From: Amanda Scholes on behalf of Planning.Responses
Sent: 08 June 2020 11:59
To: Planning Scanning
Subject: FW: LU 90 20 DOC - Parcels A2 and B6, Hampton Park PLAN 032669

Subject: LU 90 20 DOC - Littlehampton

Southern Water cannot recommend discharge of Condition 10 and 13 relating to foul and surface water drainage. The submitted drainage layout shows attenuation tank within 5 meters of public foul rising main. No water retaining or conveying features should be located within 5 metres of the public or adoptable apparatus.

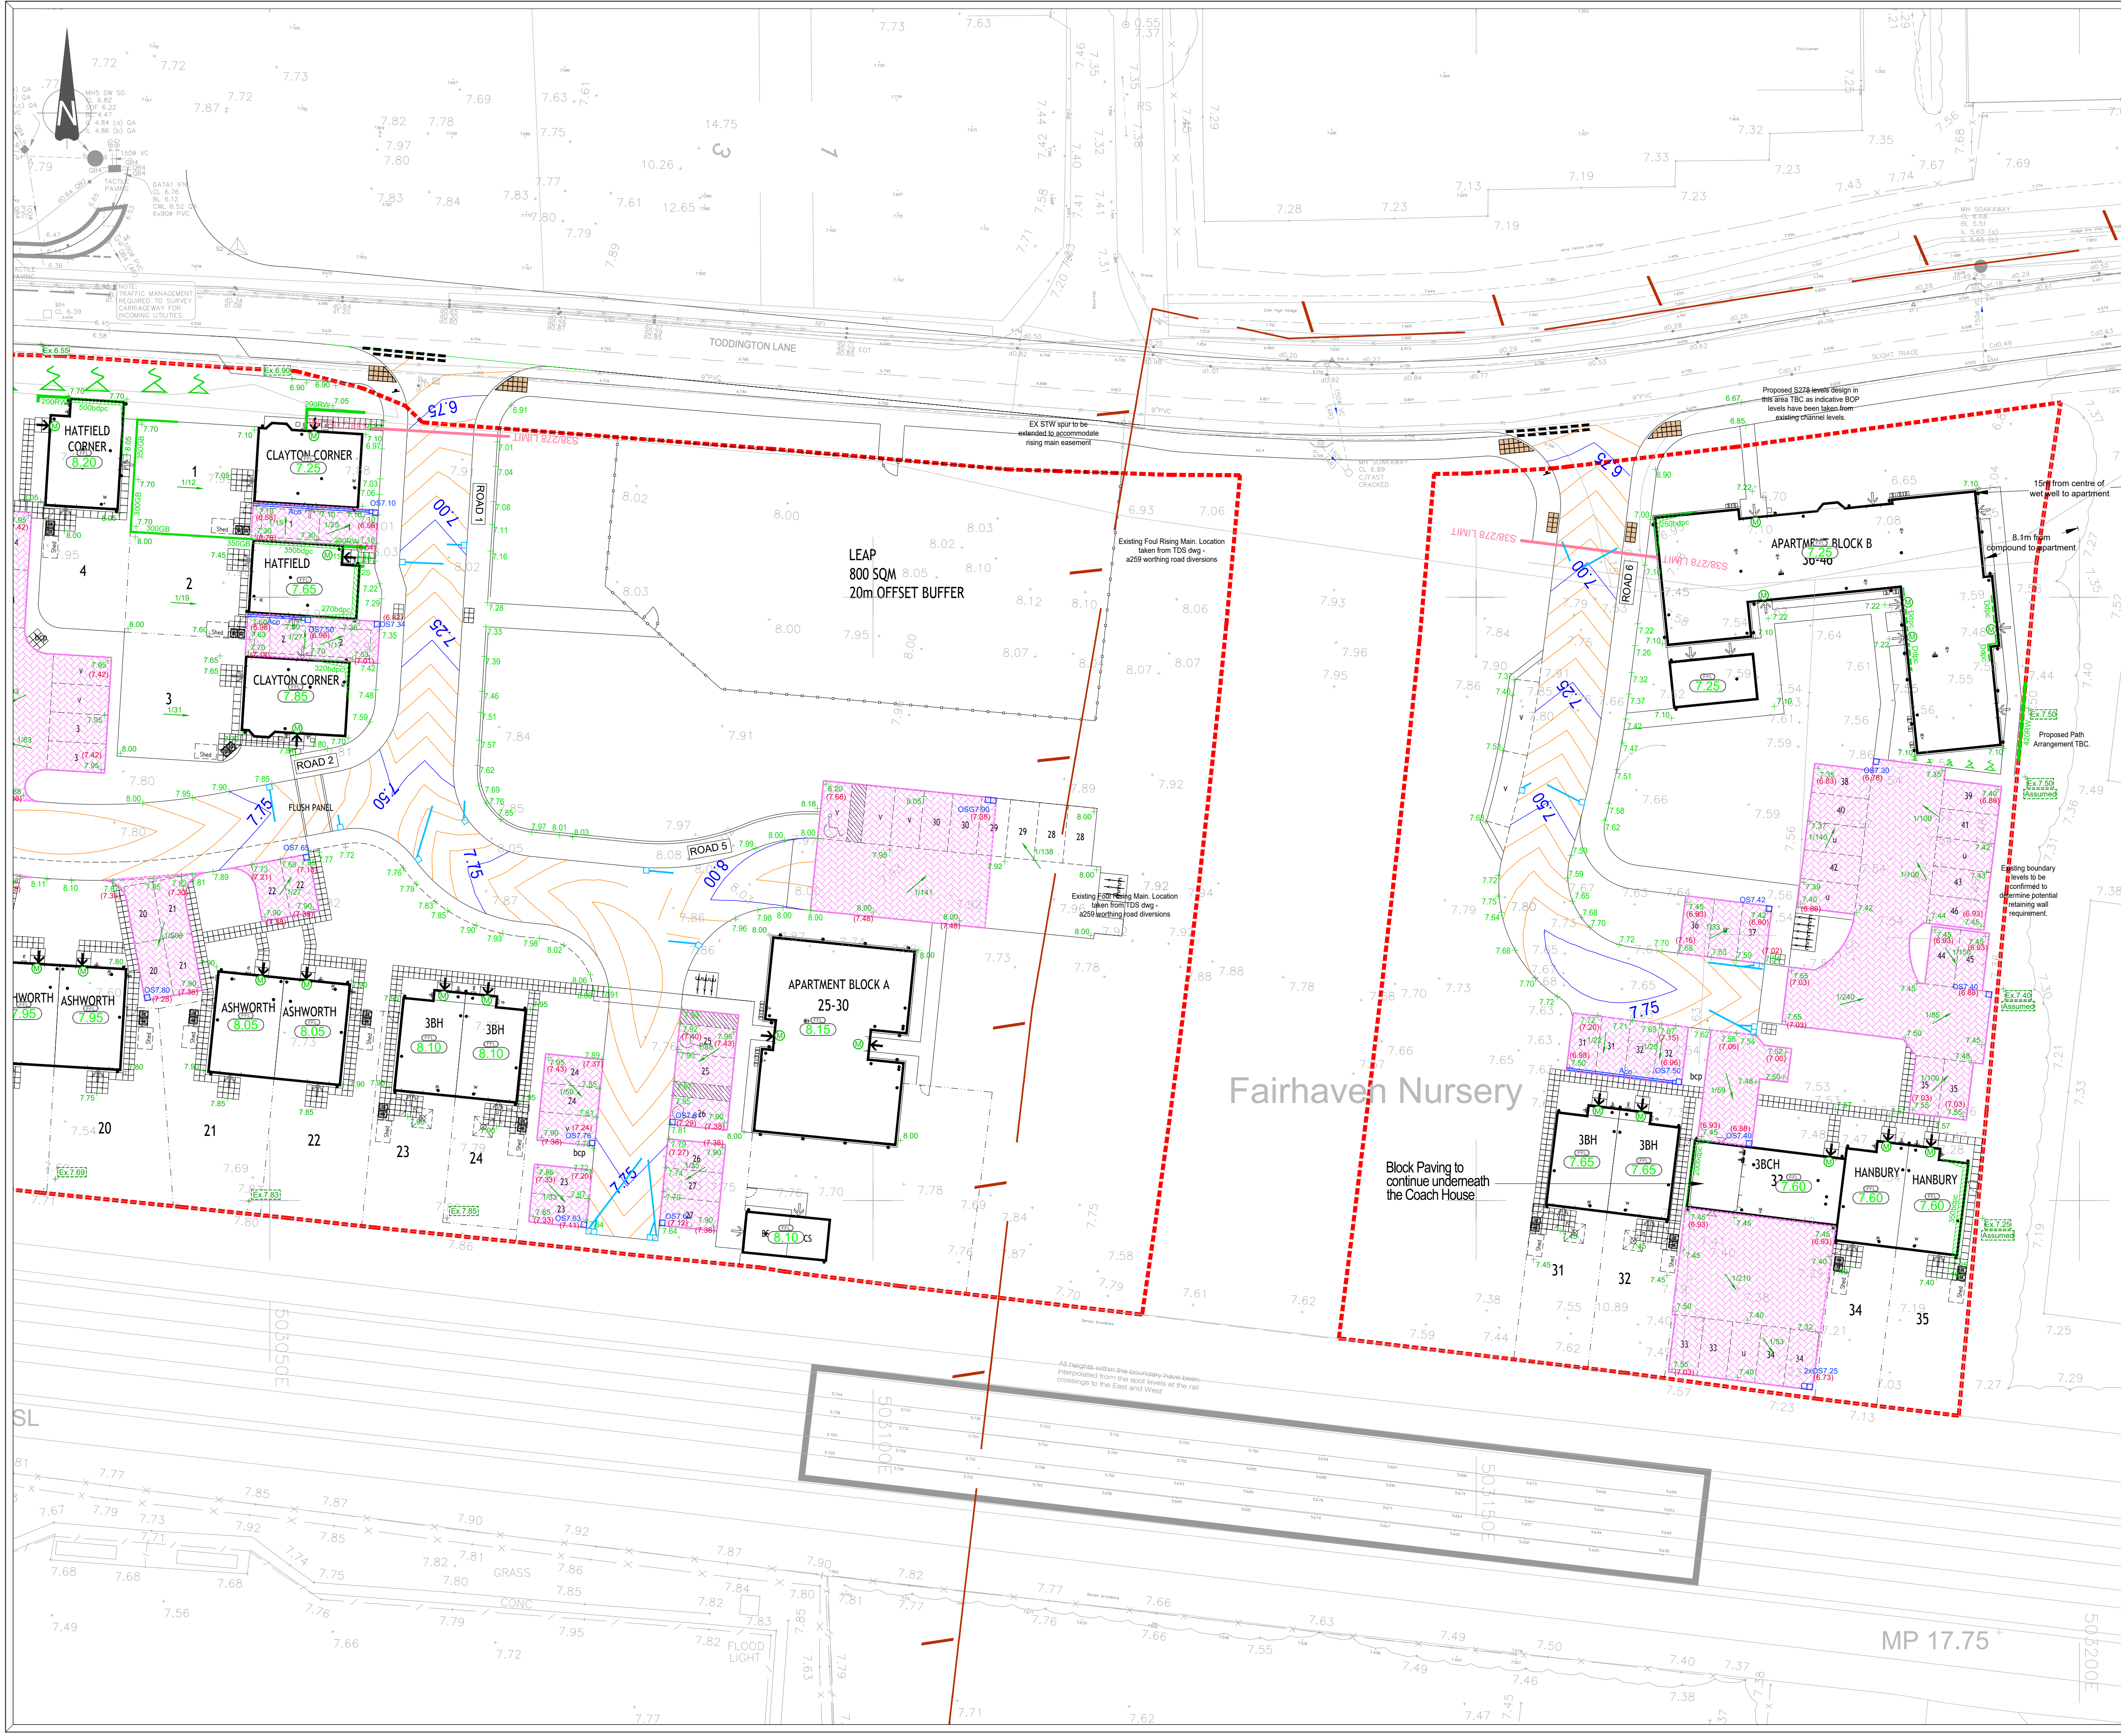
Also, the construction of tanked permeable paving over or within 5 meters of public or adoptable sewers is not acceptable to Southern Water.

Please note Attenuation tank should be sealed with impermeable membrane to avoid ingress of ground water. The design of surface water drainage should ensure that no overflow from ponds is to enter public or adoptable sewers network.

It appears that the plots 36-45 are in close proximity to an existing public foul rising main. A clearance of 3 meters on either side of the external edge of the public sewer would be required and all existing infrastructure should be protected during the course of construction works.

Due to the vibration, noise and potential odour generated by sewage pumping stations, no habitable rooms should be located closer than 15 metres to the boundary of an existing pumping station site. Southern Water requires existing access arrangements to public wastewater pumping station to be maintained with regards to unhindered 24 hour / 7 days a week access.

The Southern Water rising main is shown on the attached drawings. I can confirm we have now repositioned the tank/ permeable paving so it is no longer within 5 metres of the rising main/ adopted sewer (see attached drawing 19163 – 102 Rev F).

And you will see that plots 36-45 are not within 3 metres of the rising main. Moreover, this block of apartments is 15 metres from the centre of the wet well, as shown on the attached drawings; this was previously confirmed by you.
